Application for a non-material amendment following a grant of planning permission.

Number	12
Suffix	
Property name	
Address line 1	Tennyson Road
Address line 2	
Address line 3	
Town/city	Bognor Regis
Postcode	PO21 2SB
Description of site location must be completed if postcode is not known:	
Easting (x)	492585
Northing (y)	99156
Description

Demolition of existing garage & erection of 1 No. dwelling (resubmission following BR/121/17/PL)

Reference number: BR/257/17/PL

PROPOSED FLOOR PLANS

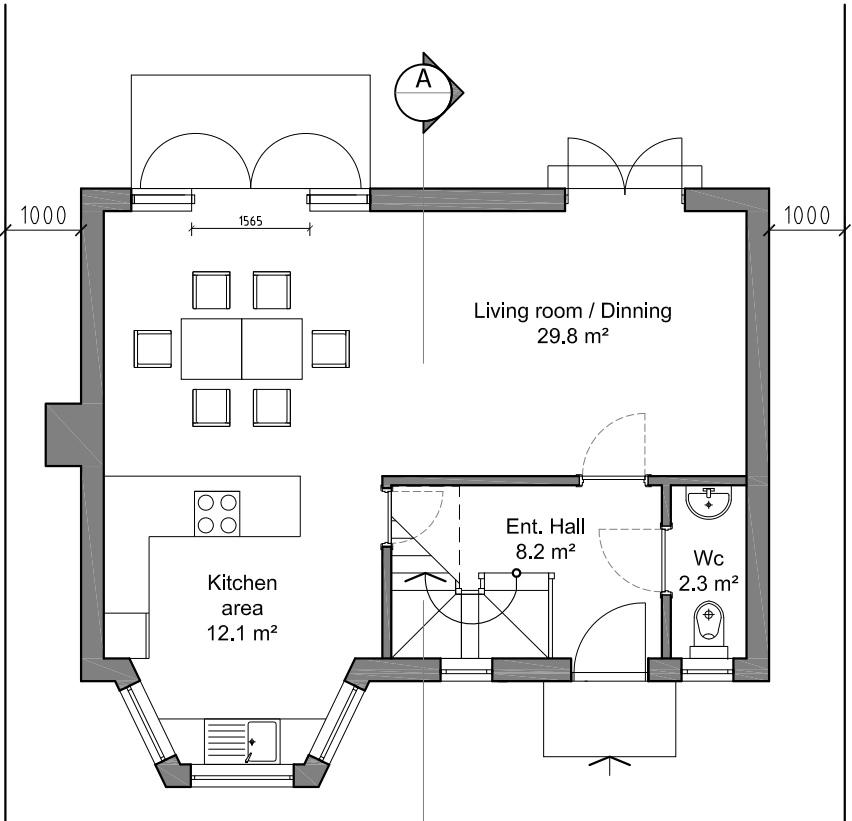
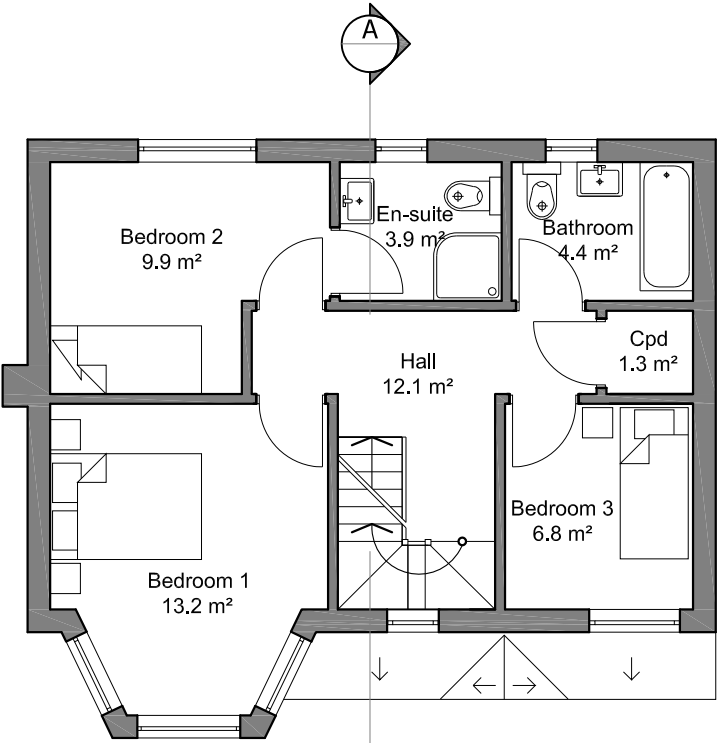
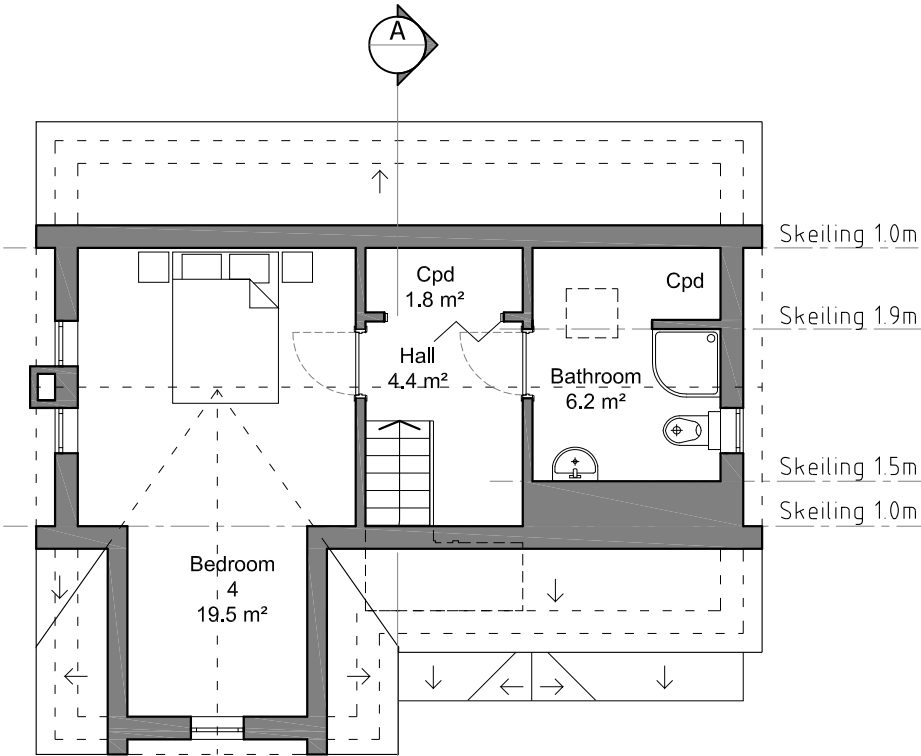
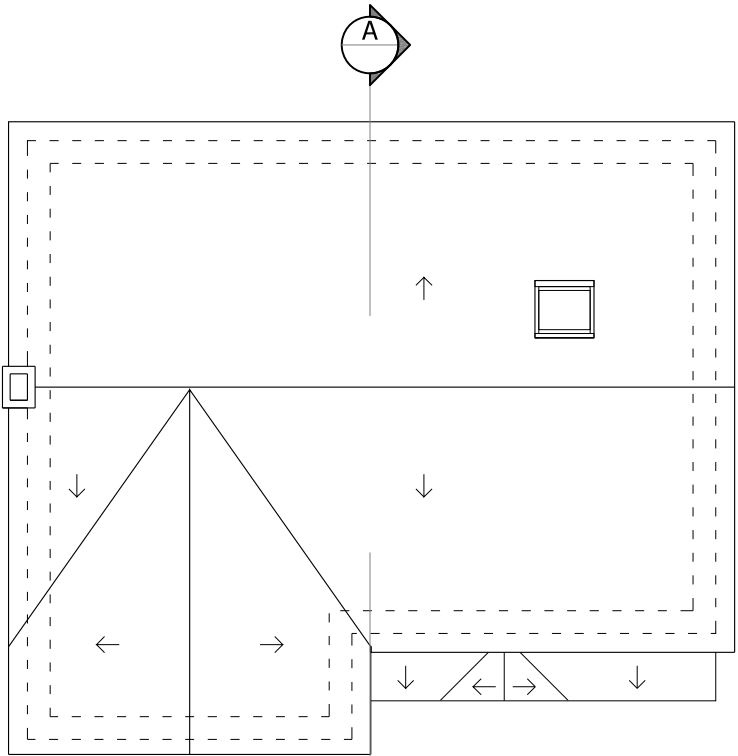
Shift entrance door's location.
Shift staircase's position.
Additional rear velux windows.

1305 101 - Proposed site plan (No change)
1305 102 B - Proposed floor plans;
1305 103 B - Proposed elevations;
